May 9, 2023

**RE: The Springs of Ballentine – Fire Sprinkler  
Fuquay-Varina, NC – Harnett County**

Plans relative to the above-named project received on April 27<sup>th</sup>, 2023 have been reviewed for general compliance with the 2018 North Carolina Building Code and the National Fire Protection Association (NFPA 13) Standard for the Installation of Sprinkler Systems, 2013 edition. Per Chapter 23 of this standard, the following shall be submitted with working plans to perform a complete review.

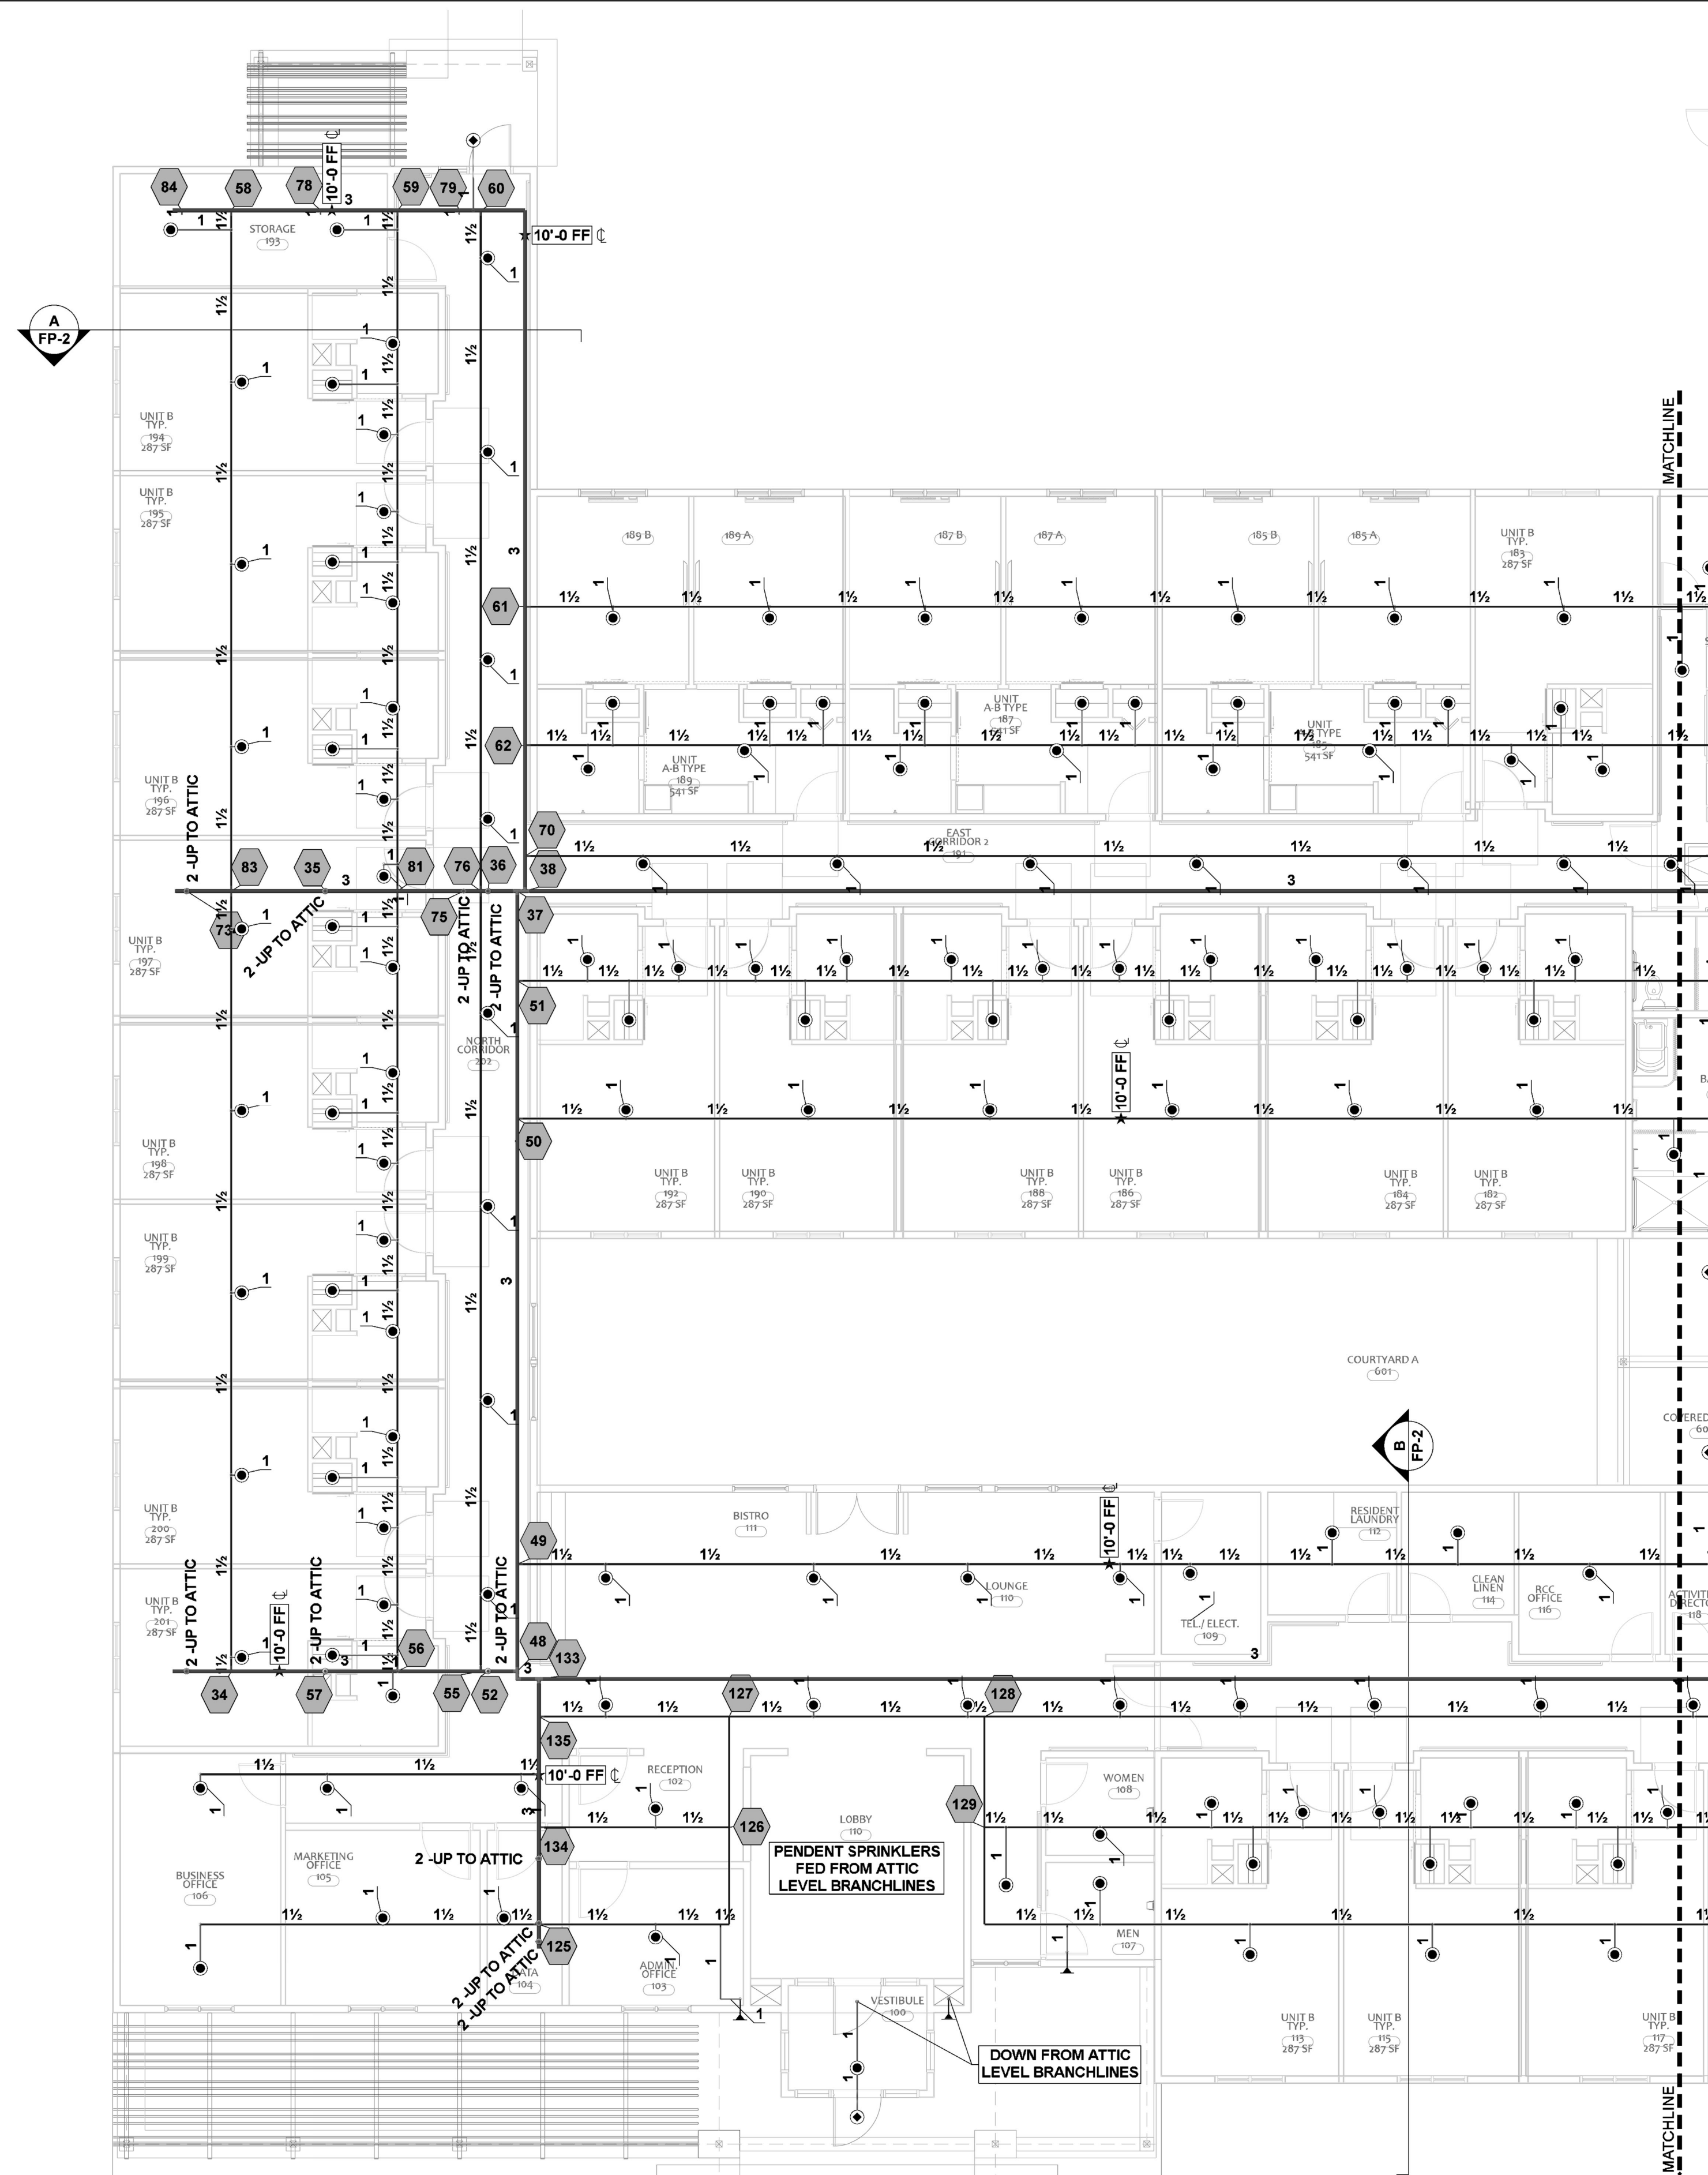
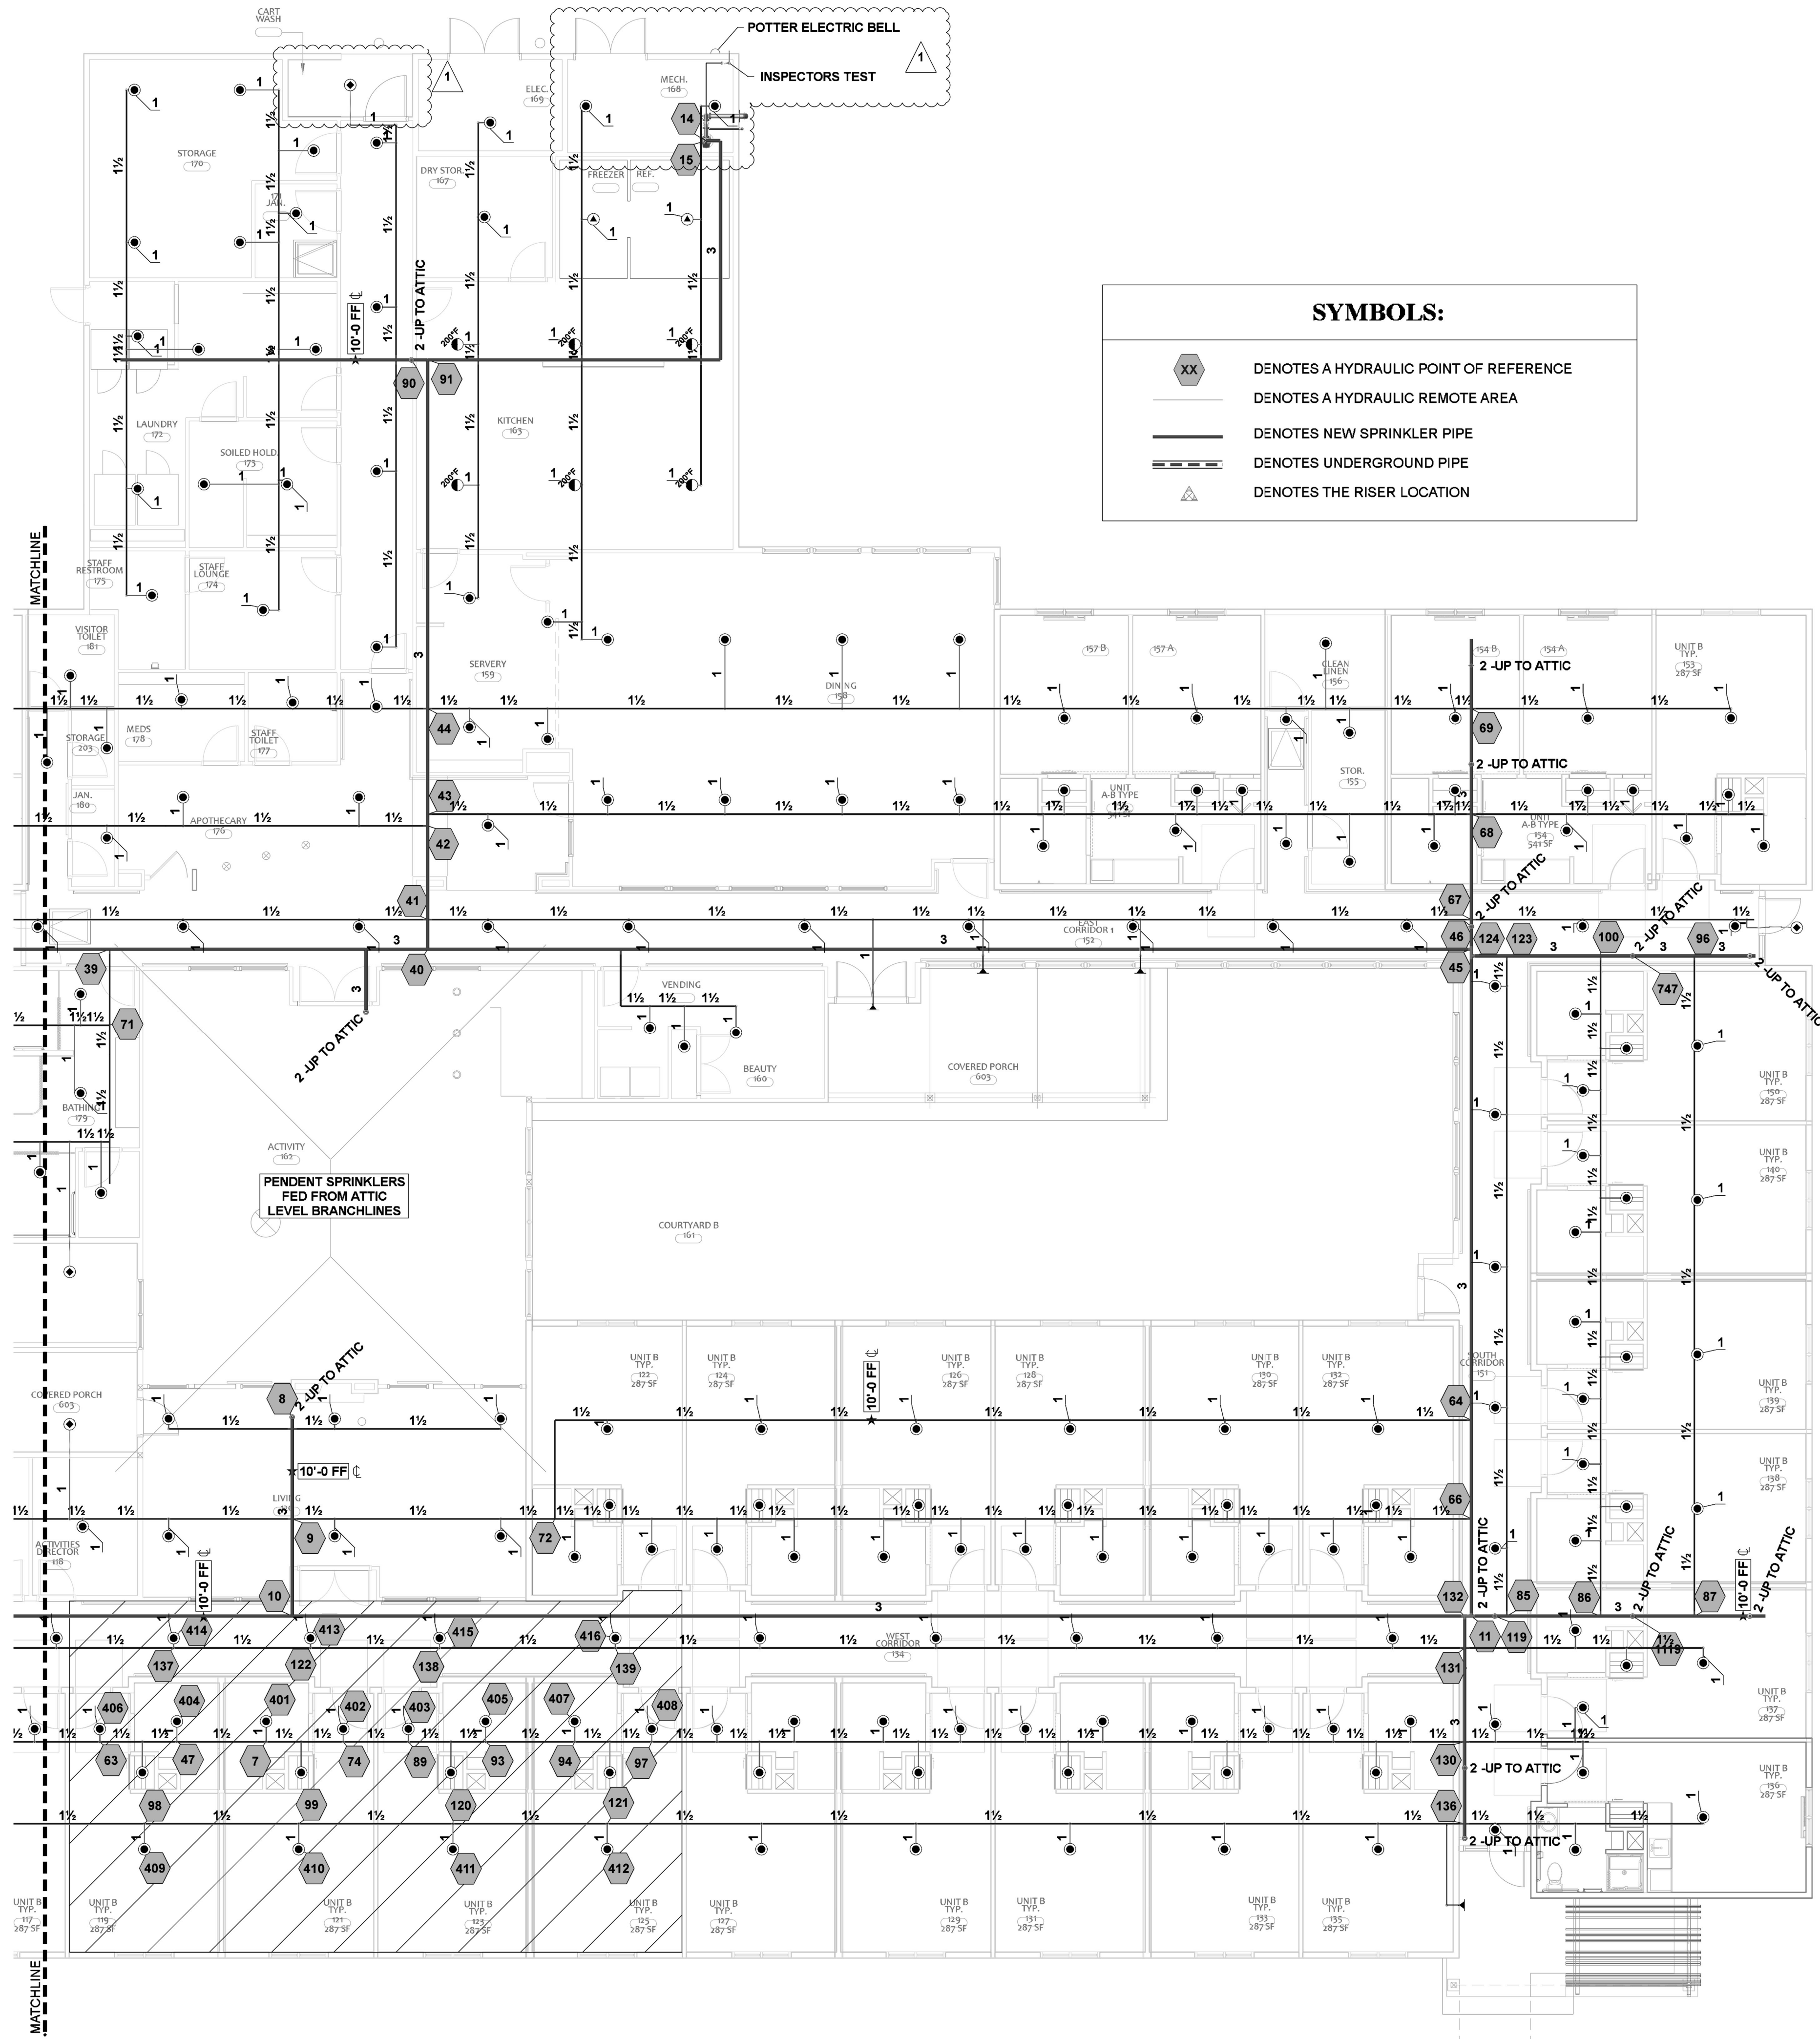
3. Are there any small enclosures in which no sprinklers are to be installed (near Apothecary 176 & Servery 159?) per NFPA 13, Chapter 23, section 23.1.3 #9.

5. Provide total area protected by each system on each floor per NFPA 13, Chapter 23, section 23.1.3 #14.
6. The head count for the Victaulic V3506 appears to not match the plans (too low). Please confirm. This may also impact Viking head VK3021.

7. The sprinkler head outside rear entry near Electric Room 169 appears to not be the correct symbol for the intended head.

8. The symbol for the heads provided in Activity 162 and Lobby 110 are not listed in the Sprinkler head legend.
9. Provide cut sheets for inspectors' test connections per NFPA 13, Chapter 23, section 23.1.3 #23.

10. Show location of the inspectors' test valve on the plan view.
11. Provide cut sheets and location for alarm bells per NFPA 13, Chapter 23, section 23.1.3 #26.
